Our Ref: 183745

**BUILDING CODE OF AUSTRALIA ASSESSMENT
1 KENSINGTON STREET, CHEPPENDALE**

We have assessed the architectural plans for internal alternations at the above mentioned premises for compliance with the Building Code of Australia (BCA) 2016 Amendment 1. The following main BCA issues associated with the proposed building work have been identified.

DRAWING
LEVEL 1
FLOOR PLAN

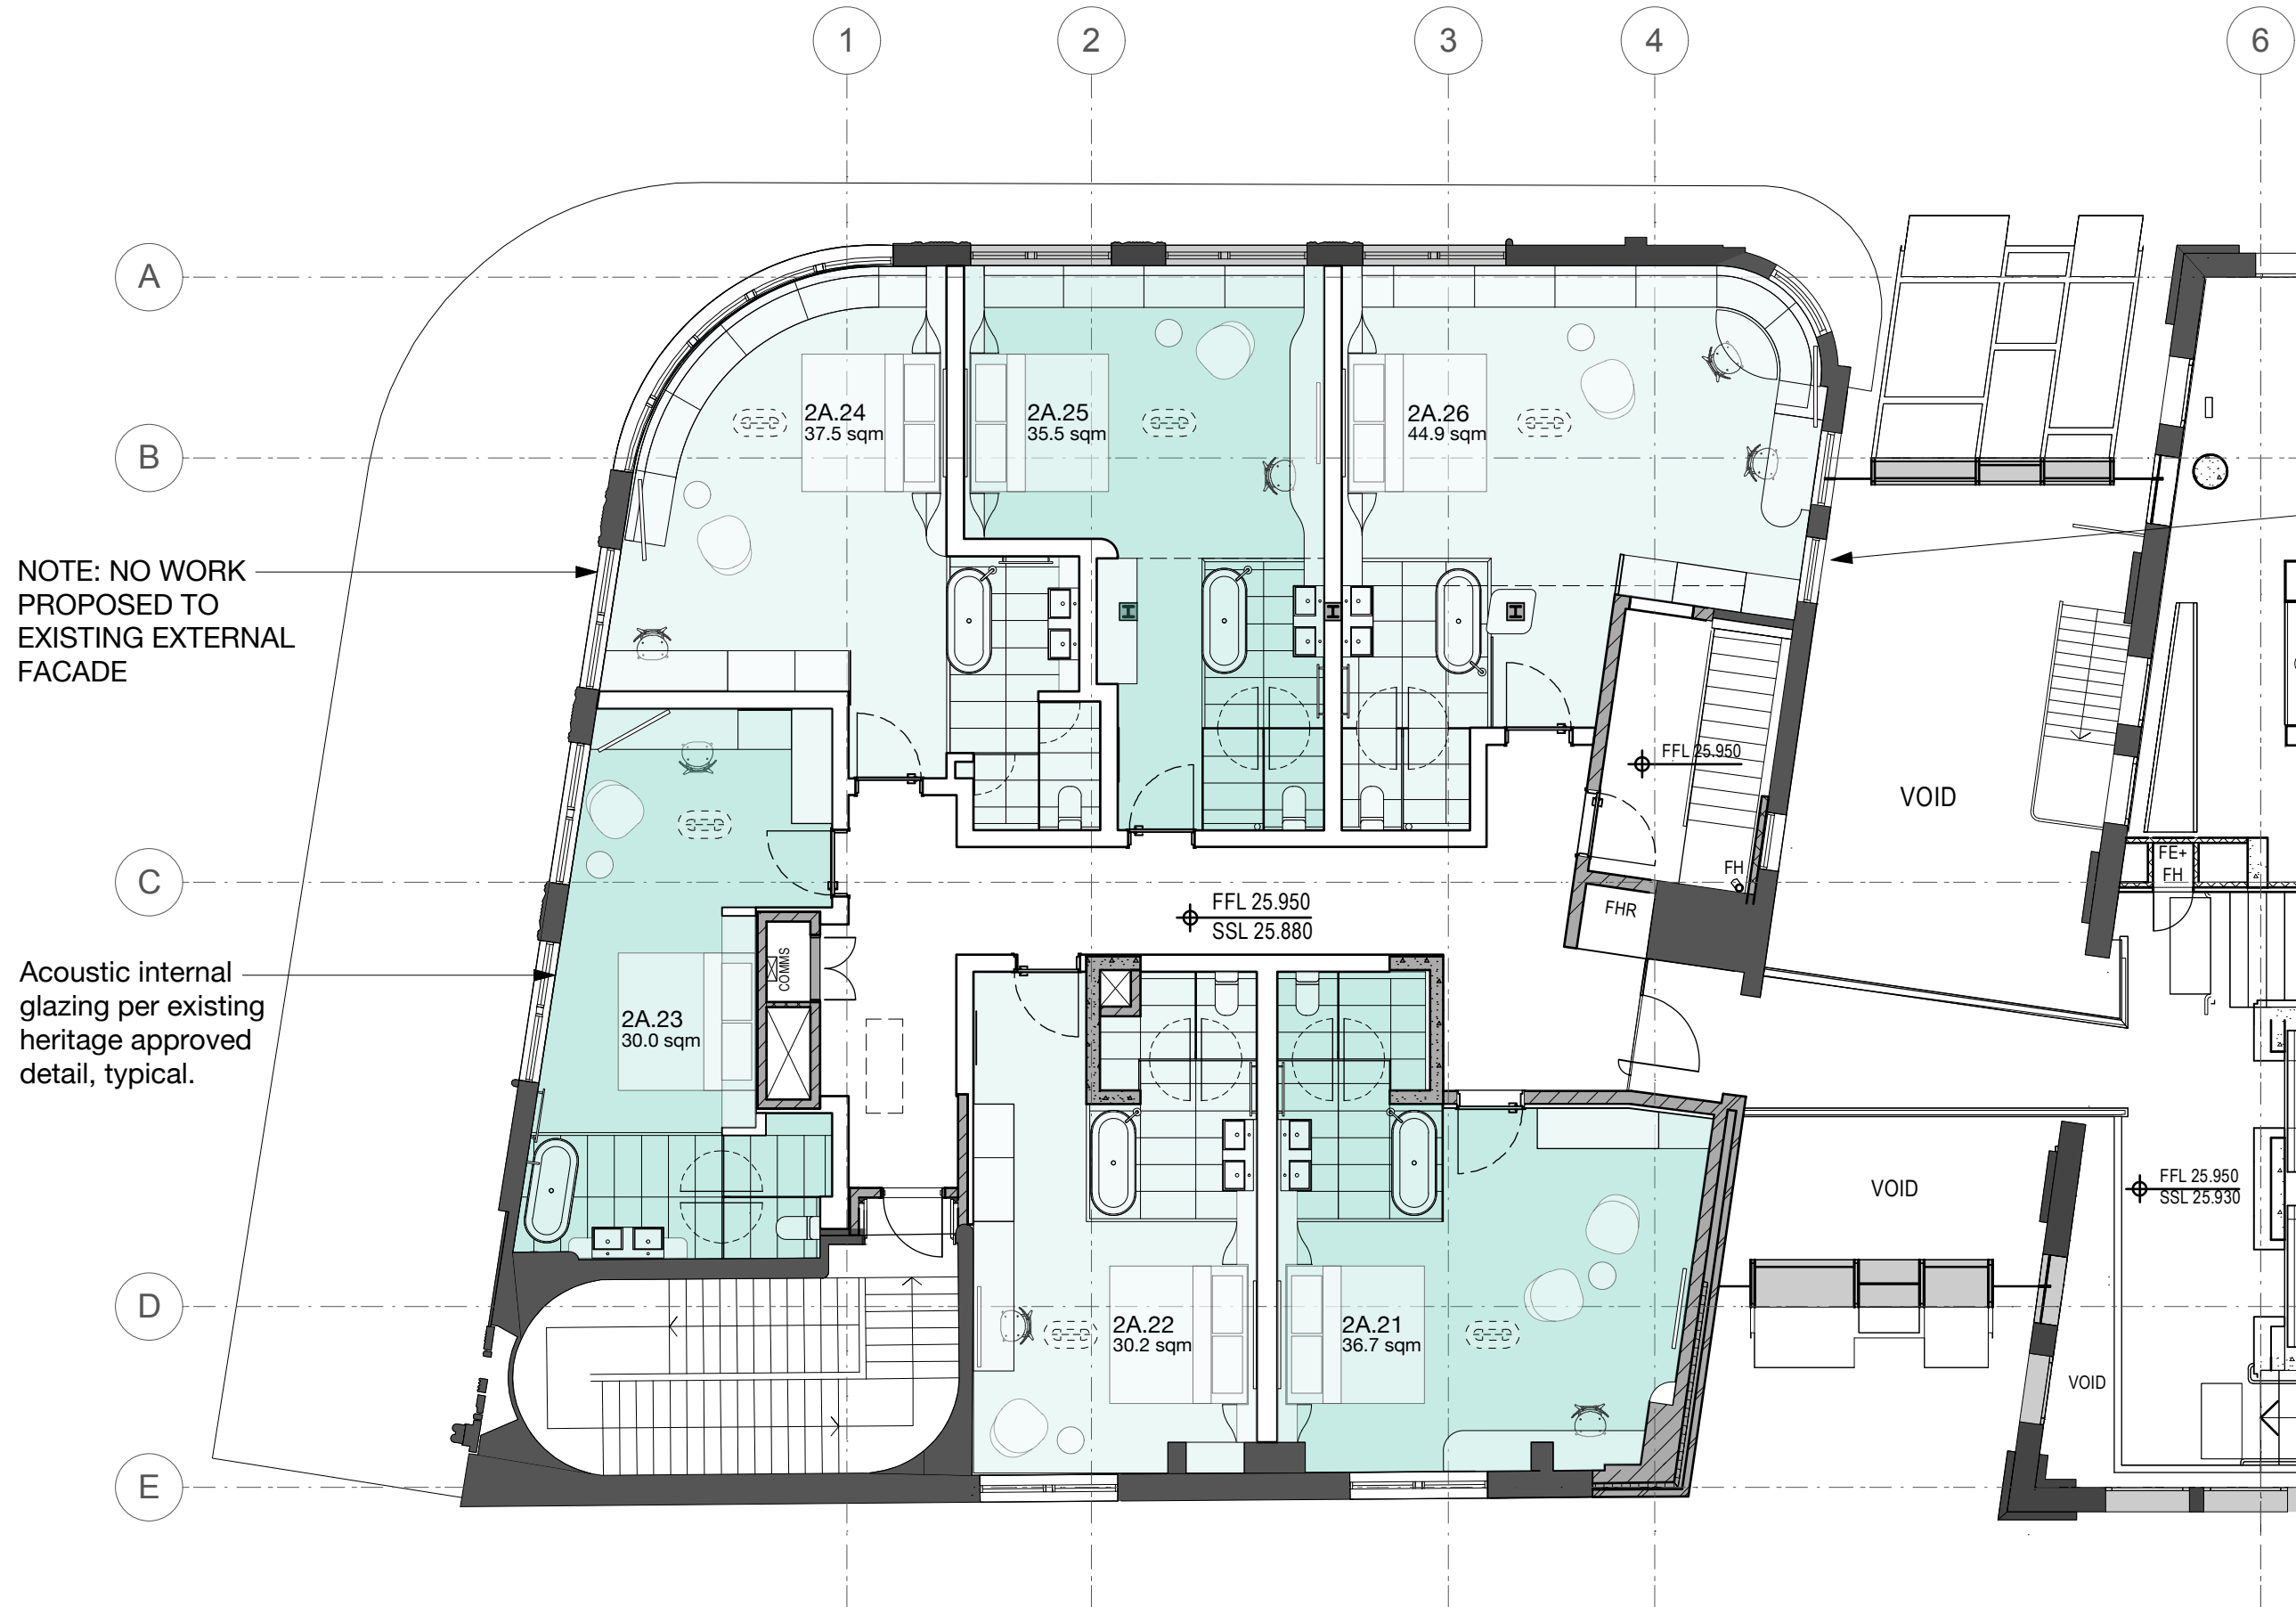
- 5.1 Hotel room 1A.07 on Level 1 will have a travel distance, from the unit entry door to a point of choice, of 8.5 m, which is more than the 6 m permitted by BCA D1.4 .

The existing FER for the building justifies extended travel to a point of choice of up to 8 m from this area of the building. The extended travel distance of 8.5 m on Level 1 is required to be performance justified.

DRAWING
 LEVEL 2
 FLOOR PLAN - SOUTH

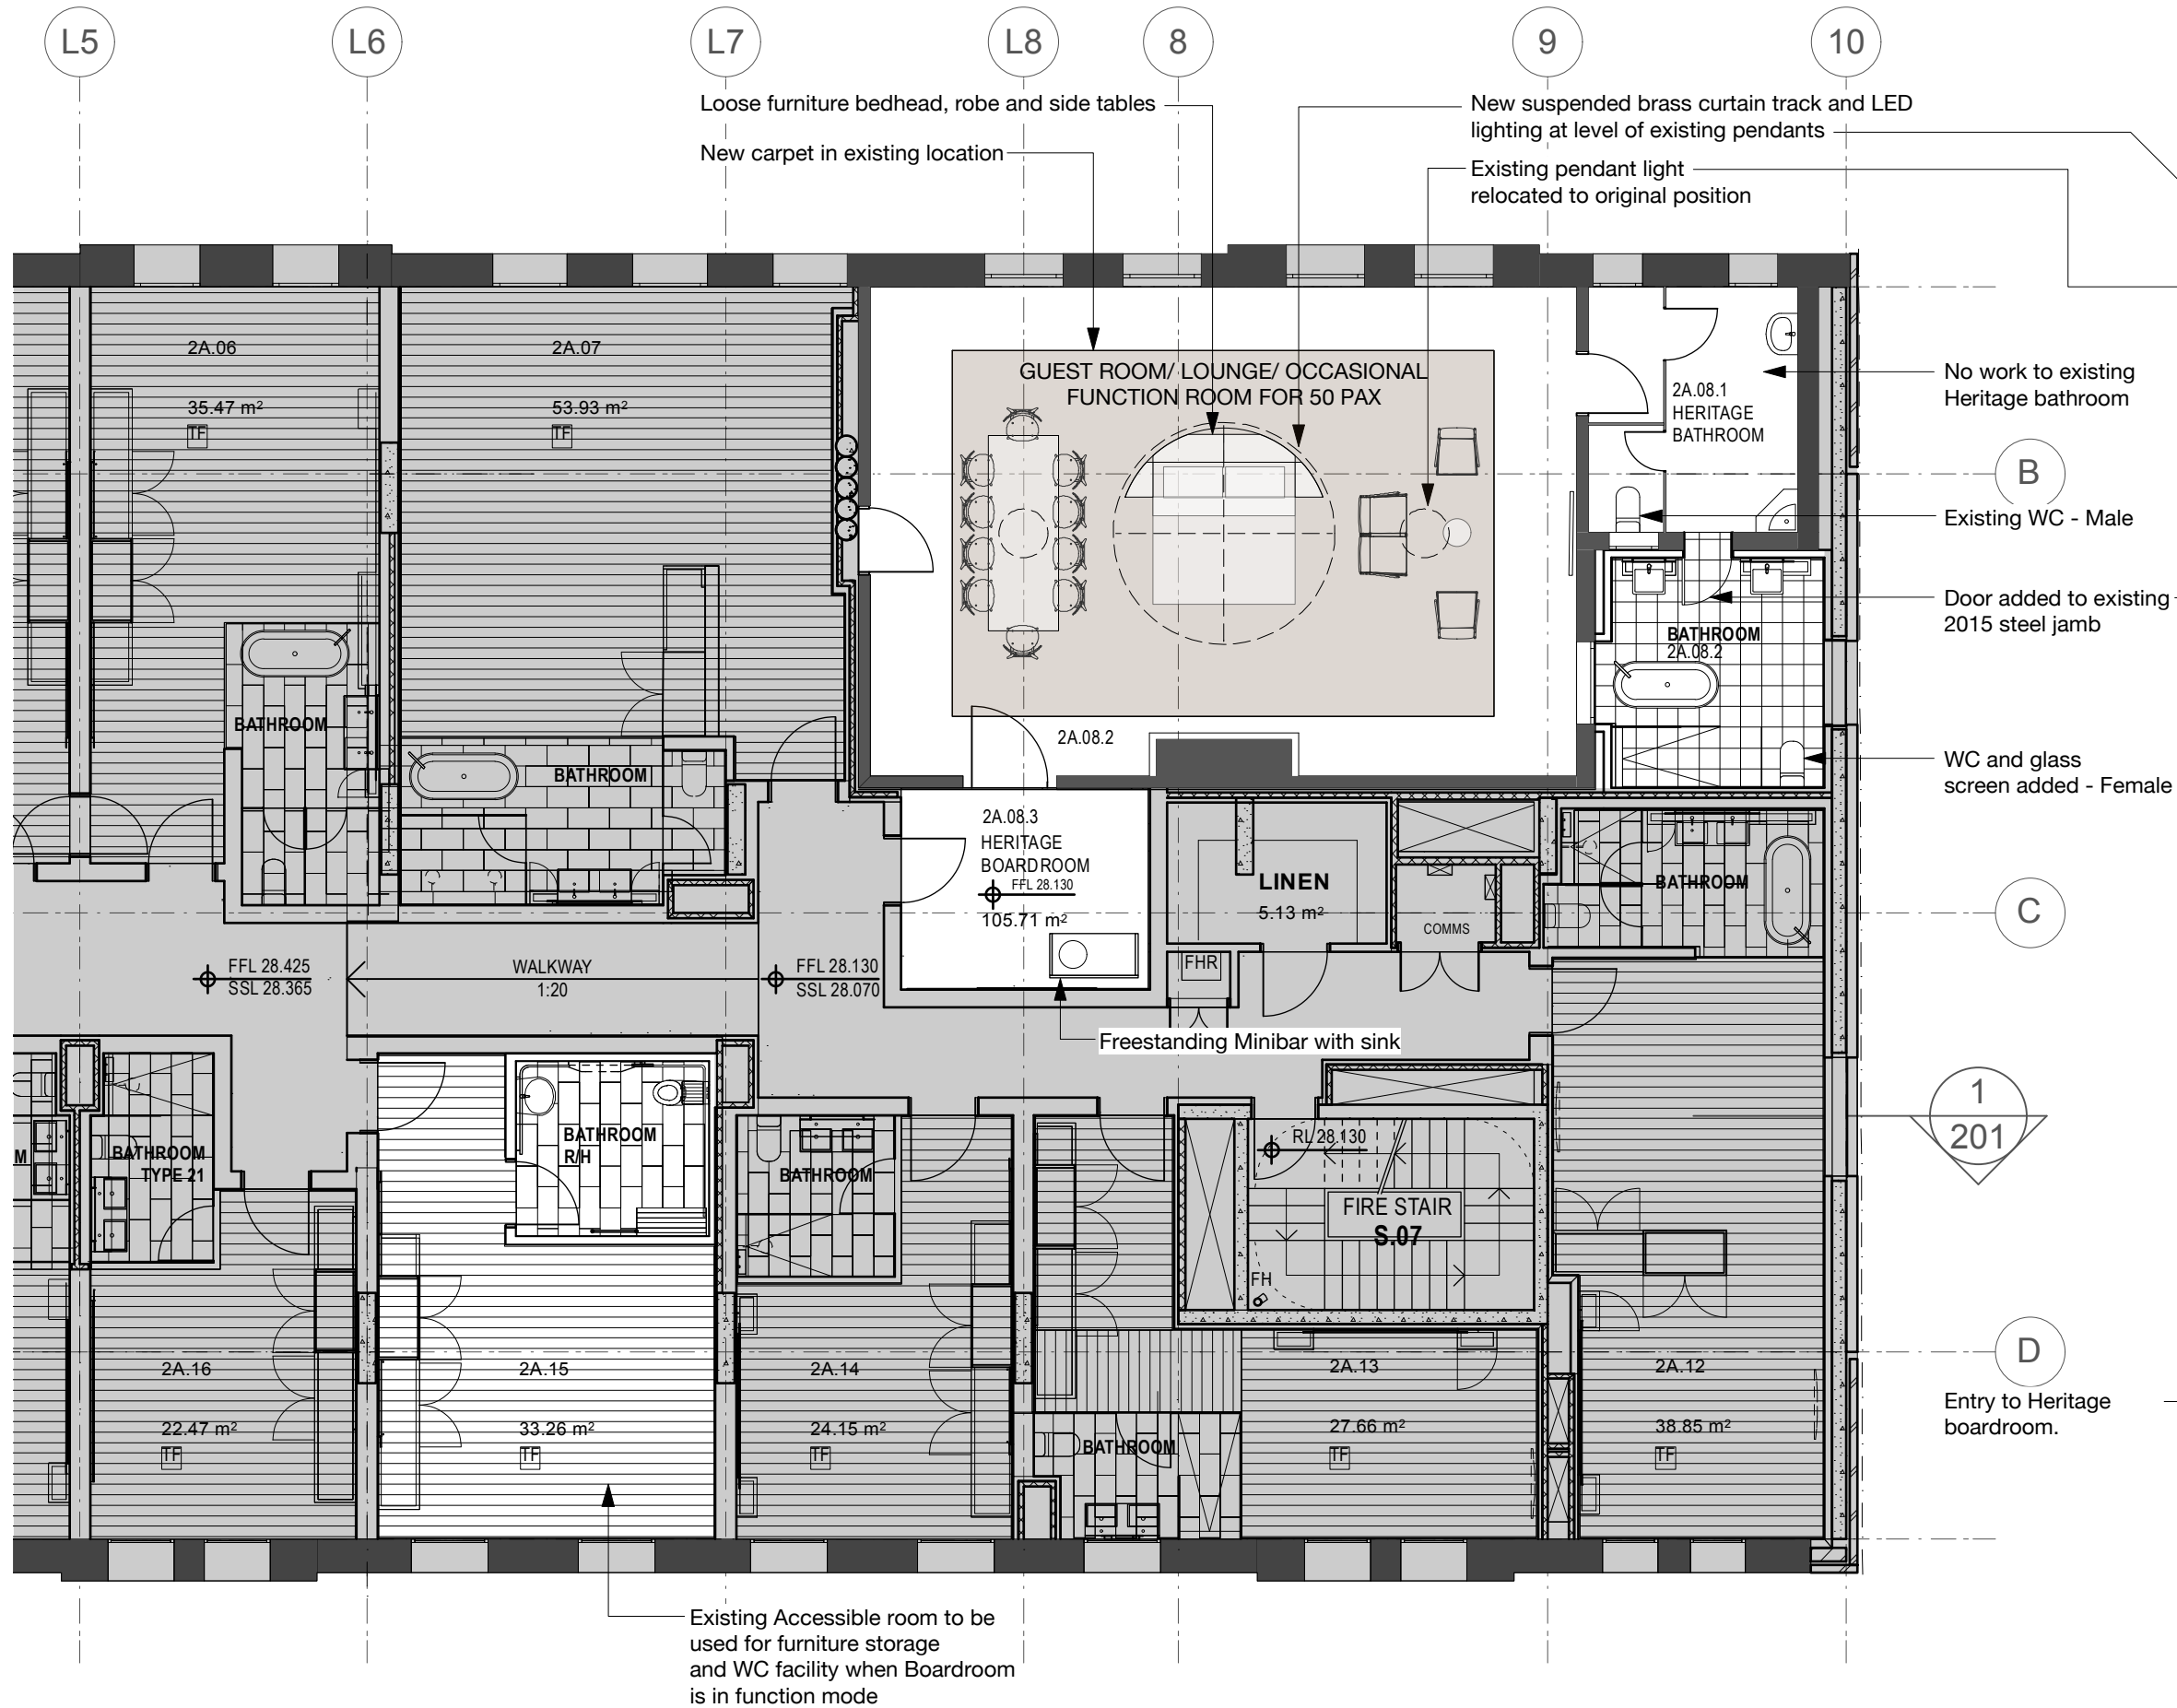
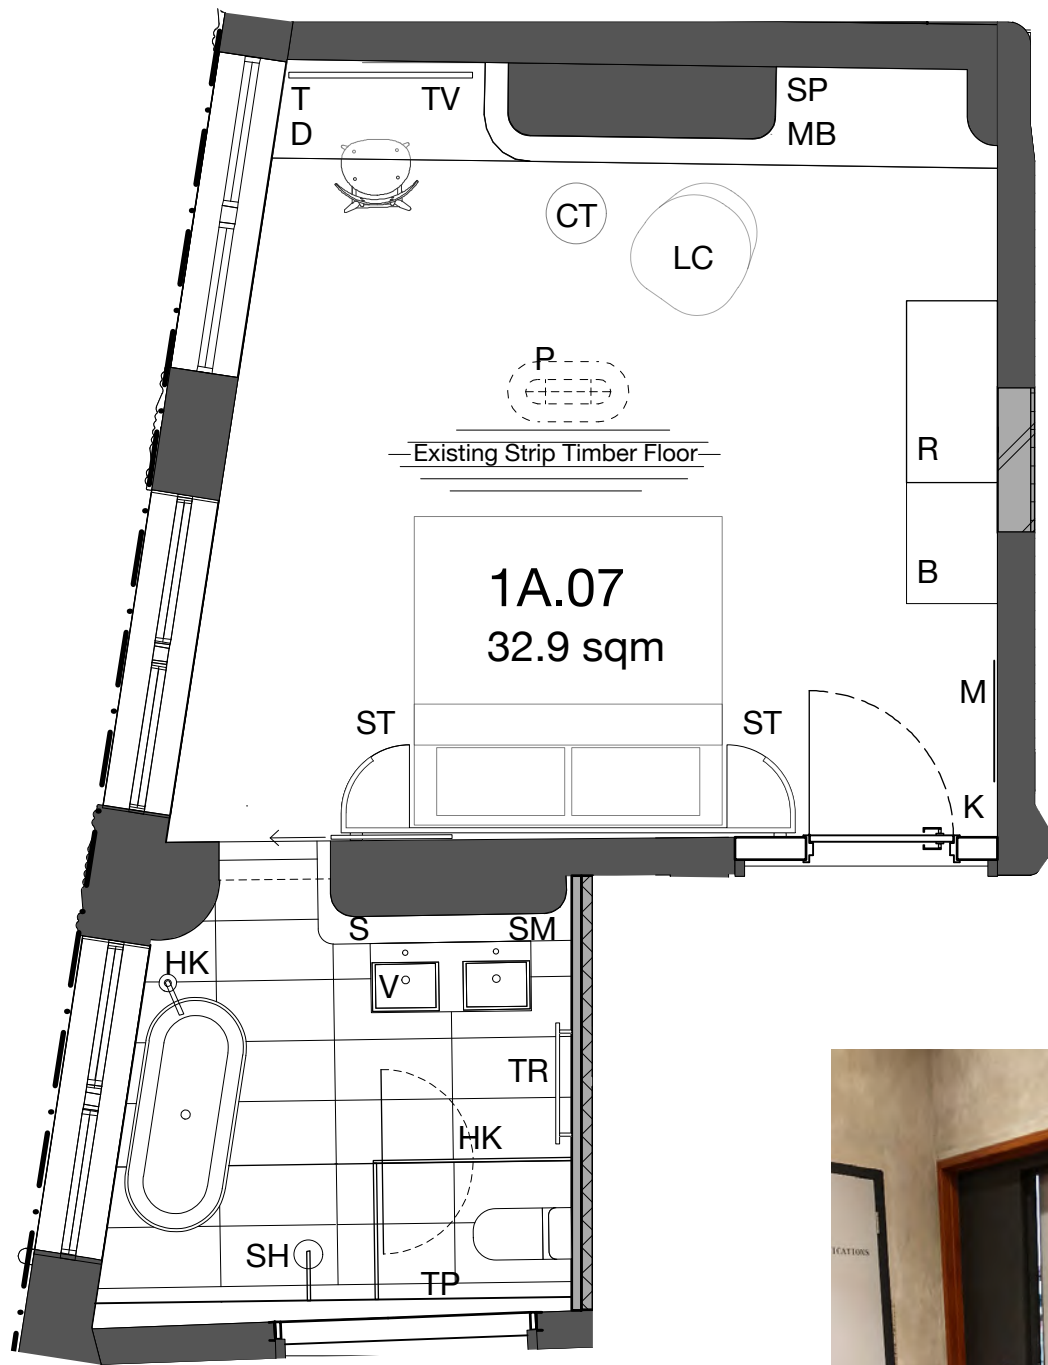
4.7 The location of the fire separation between the boardroom and the common corridor is required to be established. If the airlock is part of the common corridor (not fire separated from main corridor), then the minibar must not be located within the airlock.

On Level 2 the new rooms have a maximum travel to a point of choice of up to 10 m.

The extended travel distance of 10 m on Level 2 is required to be performance justified.

- 5.2 The distance between alternative exits (S.03 and the central stair) on Level 2 is 2.28 m which is less than less than 9 m minimum specified in BCA D1.5.

The existing FER for the building justified reduced distance between exits of 3.4 m on Level 1. The reduced distance between exits on Level 2 is required to be performance justified.

- 6.3 Signage is required to the S.03 fire stair door on Level 2 in accordance with BCA D3.6(a)(ii):
